Urban Design Observations		Officer:		Stephen Kilmartin	
Description:	Land East of Chipping Lane				
Application Ref:	2016/0193	Case Officer:	S.K	 Ribble Valley Borough Council www.ribblevalley.gov.uk	
Response Ref:	2016/0193/UD/01	Issue Date:	24/03/15

2010 Range - The Foxton
(2 STOREY WITHOUT BALCONY)

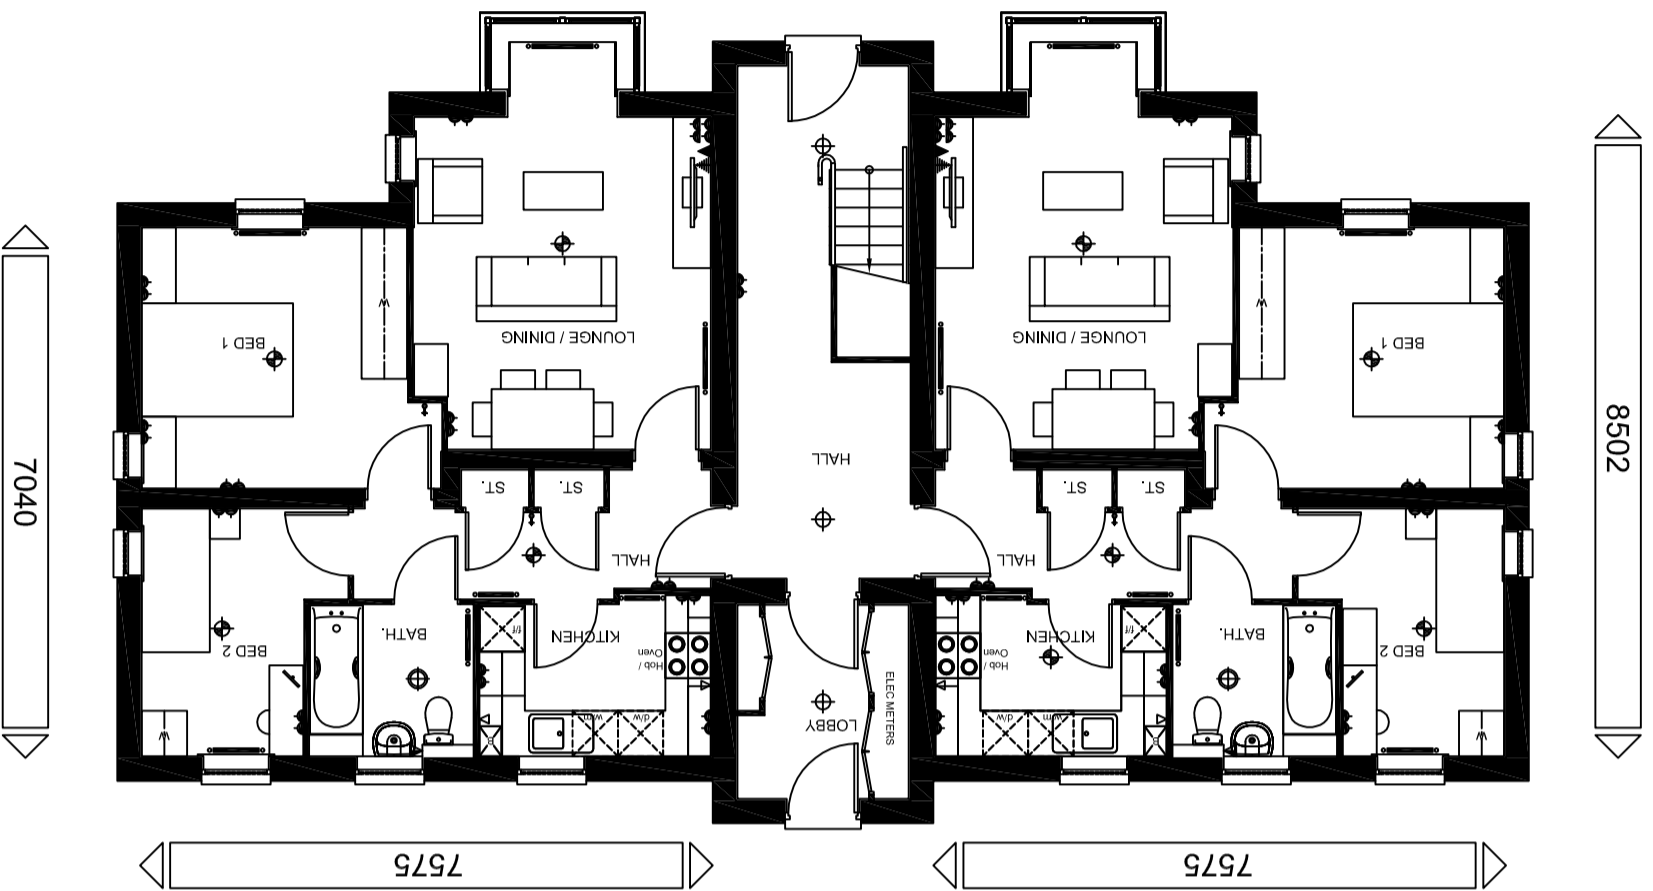
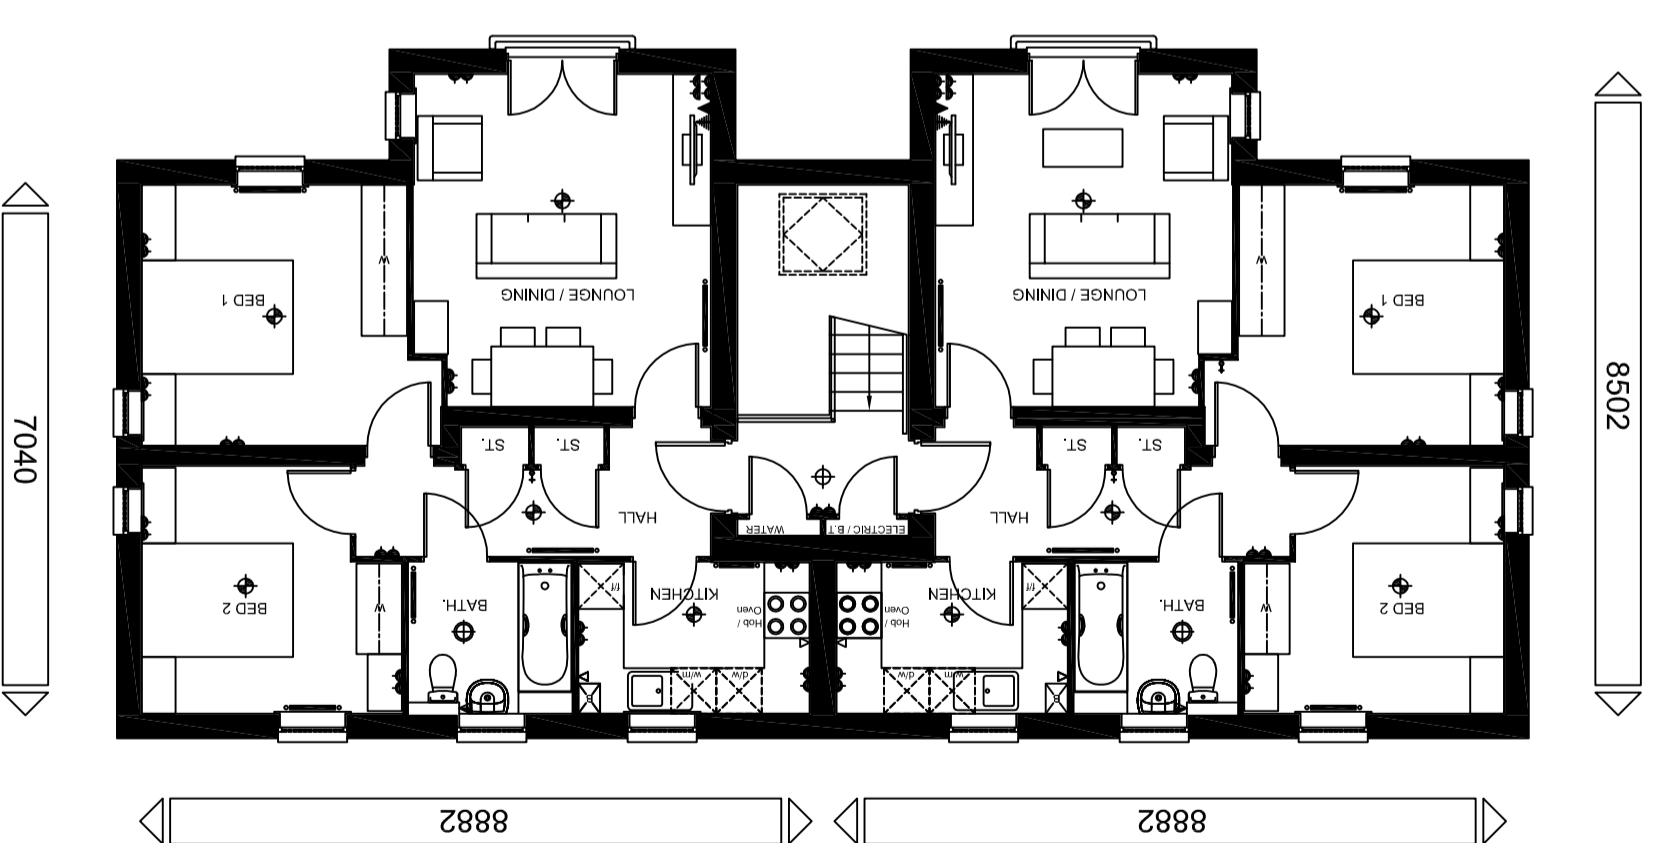
2.10 I have concerns in relation to potential the oblique overlooking issue resultant from the proximity of plots 105-108 (Foxton) to the residential curtilage of plot 110. I have noted that there is the intention to plant trees in this location but it is likely that it would be a significant period of time before any such tree planting would provide adequate visual mitigation. I have also noted that plots 105-108 propose windows to the side elevations which would result in the direct over-looking of the private residential curtilage of plot 109.

2.12 The proximity and elevated overlooking from first floor windows directly into the private residential curtilage of plot 110 at oblique angles is considered unacceptable. You have failed to address my concerns regarding side windows and further impacts upon plot 109, in its present form the current arrangement will not be supported by the LPA.

2.13 No details of communal refuse storage have been provided for the Foxton units, I have noted that there appears to be an outbuilding within the parking area associated with the apartments and consider that this building, if to be used for refuse storage, should also include for the provision of the storage of cycles despite the units being for over 55's to encourage sustainable methods of transport especially given the evidenced increased mobility of 'elderly persons'.

2.11 (Agent response) The apartment block (Plots 105 – 108) is only 2 stories in height and is located the required distance from plot 109 so I'm unsure how this differs from any situation whereby the gable of a dwelling resides at 90 degrees to the street? The tree planting is proposed to alleviate the transition from the affordable plots to open market sale and also to enhance the area by way of soft landscaping.

- 2.14** (Agent response) The intention was for a refuse/ cycle housing to be allowed. The design of this will be issued as part of the revised planning pack.

2010 Range - The Morpeth 2

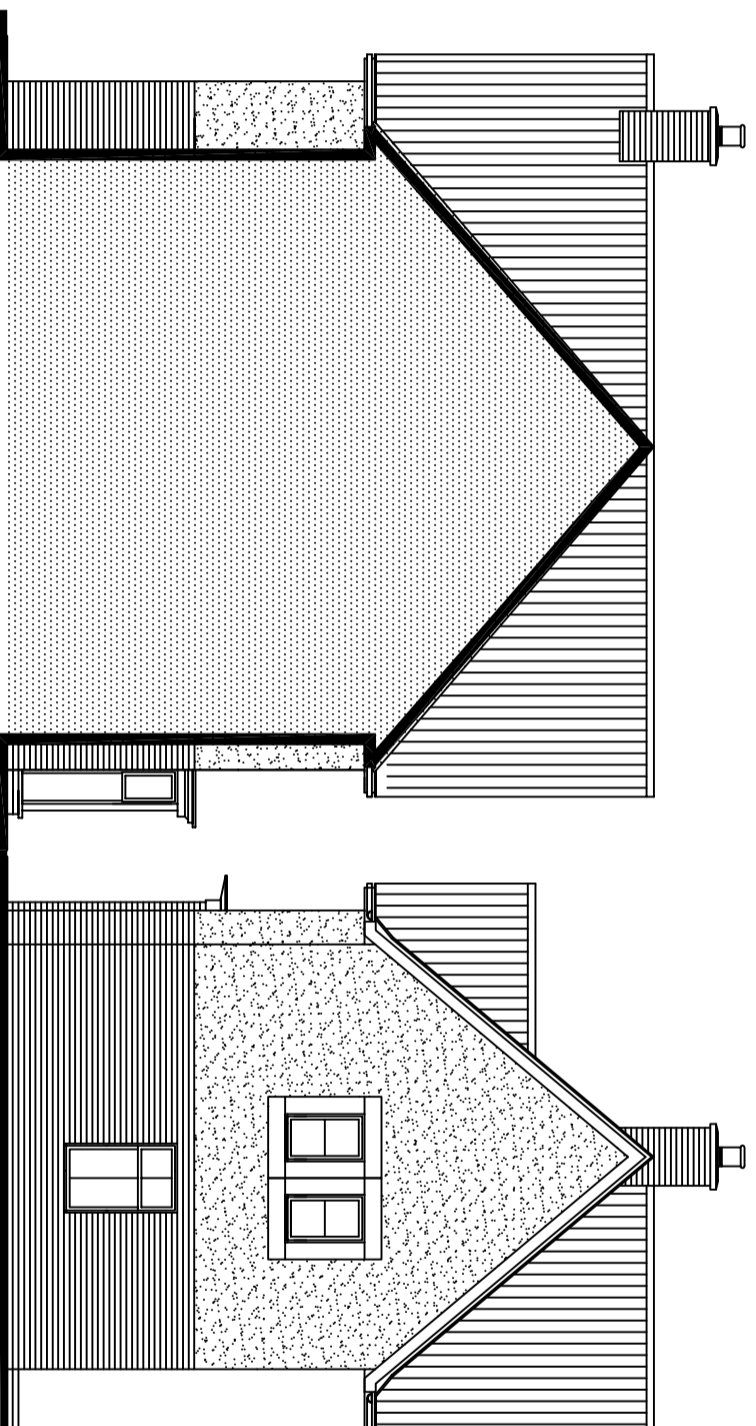
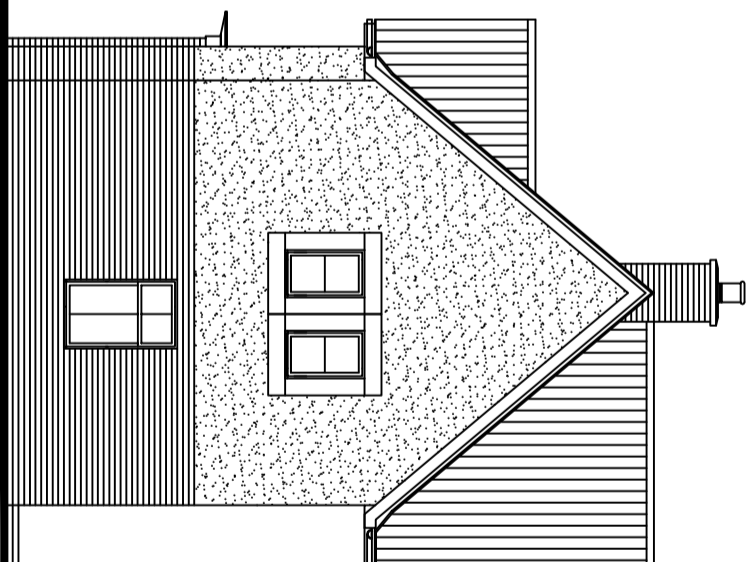
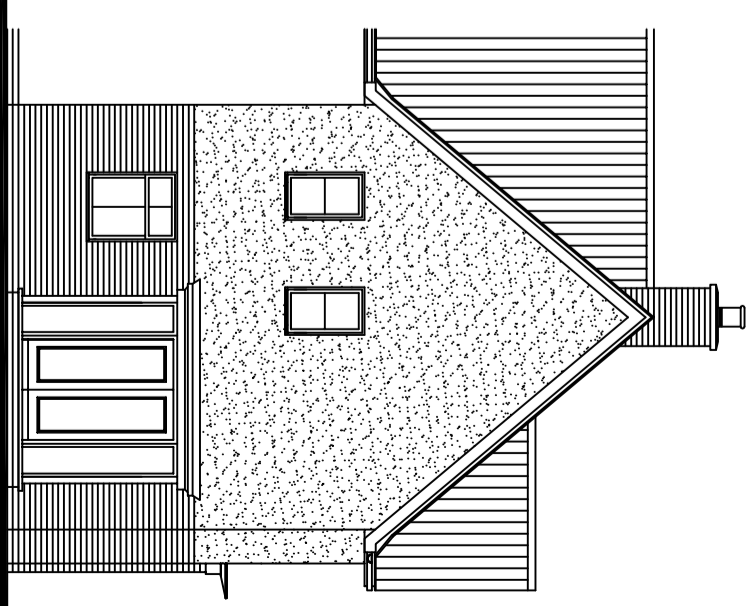
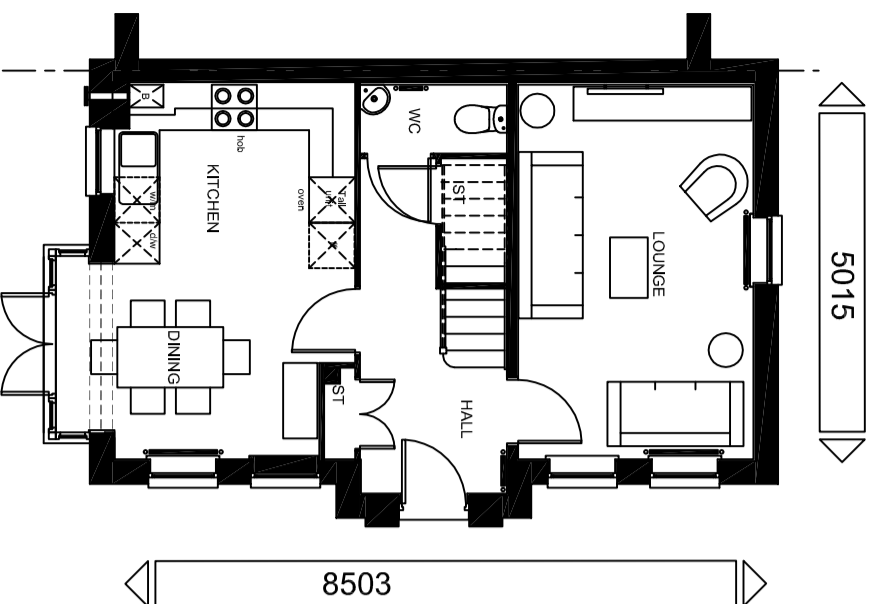
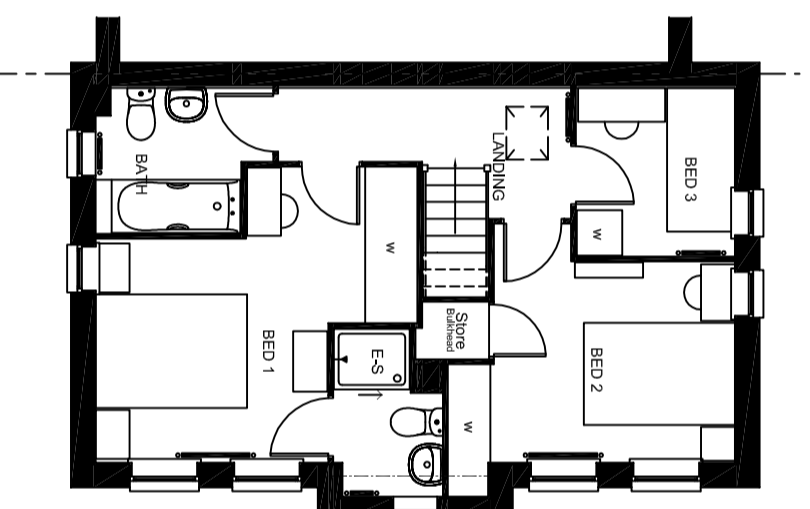
2.25 I have not been provided with any details of the Morpeth house type however I note that in a number of locations it benefits from a forward projection in relation to the inherent/adjacent building line and assume that it may be affording an inanimate elevation an undue level of visual prominence on approach or within the street scene. For example plot 68, approach from northwest.

2.26 (Agent response) This was submitted through the planning portal however I have attached again for your information. The main focus of the Morpeth type is to articulate the corners or junctions or to be cited in focal locations. The dwelling (as you will see from the attached) is a dual aspect house which has good natural surveillance over the street reducing exposed blank gables. In most cases the Morpeth has been utilised to create a narrower pinch point to the junction which we feel is necessary to instil the character of the scheme (especially with the addition of the squares), so in bringing these in to create this they do seem fragmented in the street scene. That said we don't feel that that causes any concern as the materials are picked out on these buildings as being legibility points thus allowing them to stand away from the remainder of the street. We feel strongly about this and would ask that you consider our approach for these areas.

2.27 I will provide detailed comments in respect of the revised house type designs and forward further sketch proposals to assist in design dialogue. It would assist in expediting matters if you could facilitate the sharing of your house type suites in Autocad format, this would allow me to quickly add 'sketch overlay' suggestions. Please note I am currently engaging with other applicants/developers and utilising similar work methods/ file sharing and both parties have found this to aid in frequent and rapid exchanges of concise dialogue on design matters.
